CITY OF ALBUQUERQUE

RE: 1424 Caballero Drive SE
Grading and Drainage Exhibit
Stamp Date 8-4-2016 (File:M23D008A)

DRAINAGE AND TRANSPORTATION INFORMATION SHEET (REV 1/2016)

Project Title: Sanchez Res. Building Permit #: 201690762 Hydrology File #: MA33D0084

NEW CONSTRUCTION
GRADING AND DRAINAGE

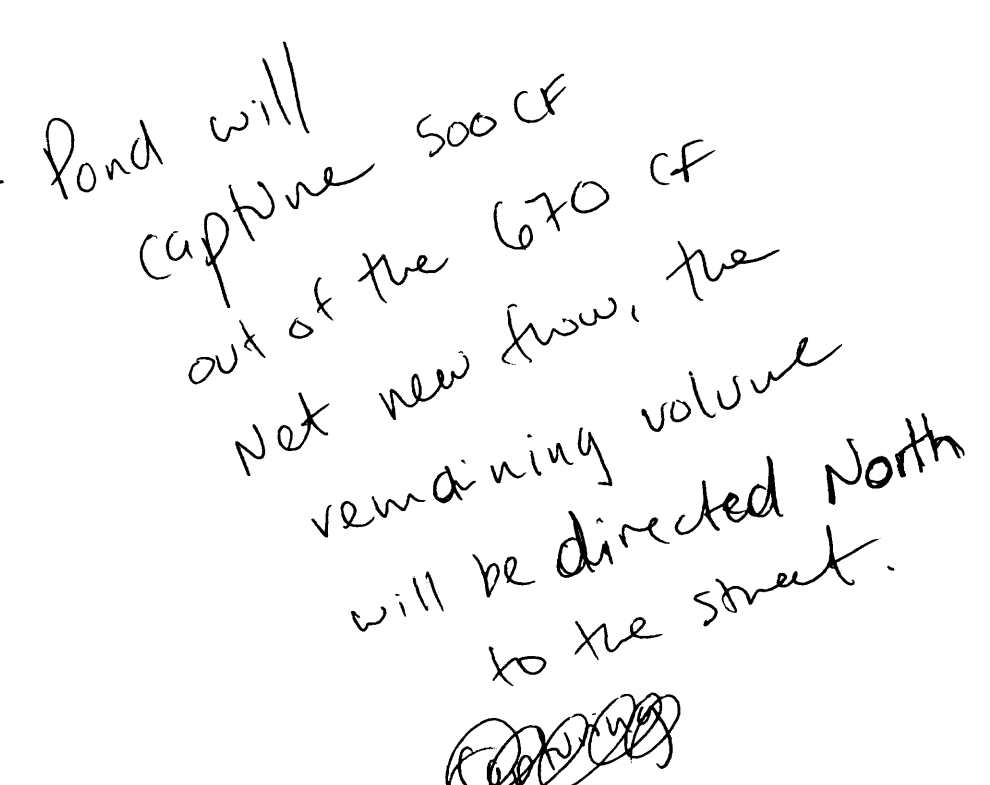
Based on the exhibit, we understand that a small pond is planned at the southern corner of the lot. This pond appears to only capture a portion of the additional runoff generated by the site, and it is unclear if the peak discharge is mitigated. However, based on the proposed retaining wall elevation and the swale shown, the remaining runoff appears to be directed to the street. Please contact me if this is not the case.

Please also ensure that this concept is maintained through construction. If this general condition is not possible during construction, a submittal will be needed to show how the discharge will be handled without increasing the historical overflow into the adjacent property.
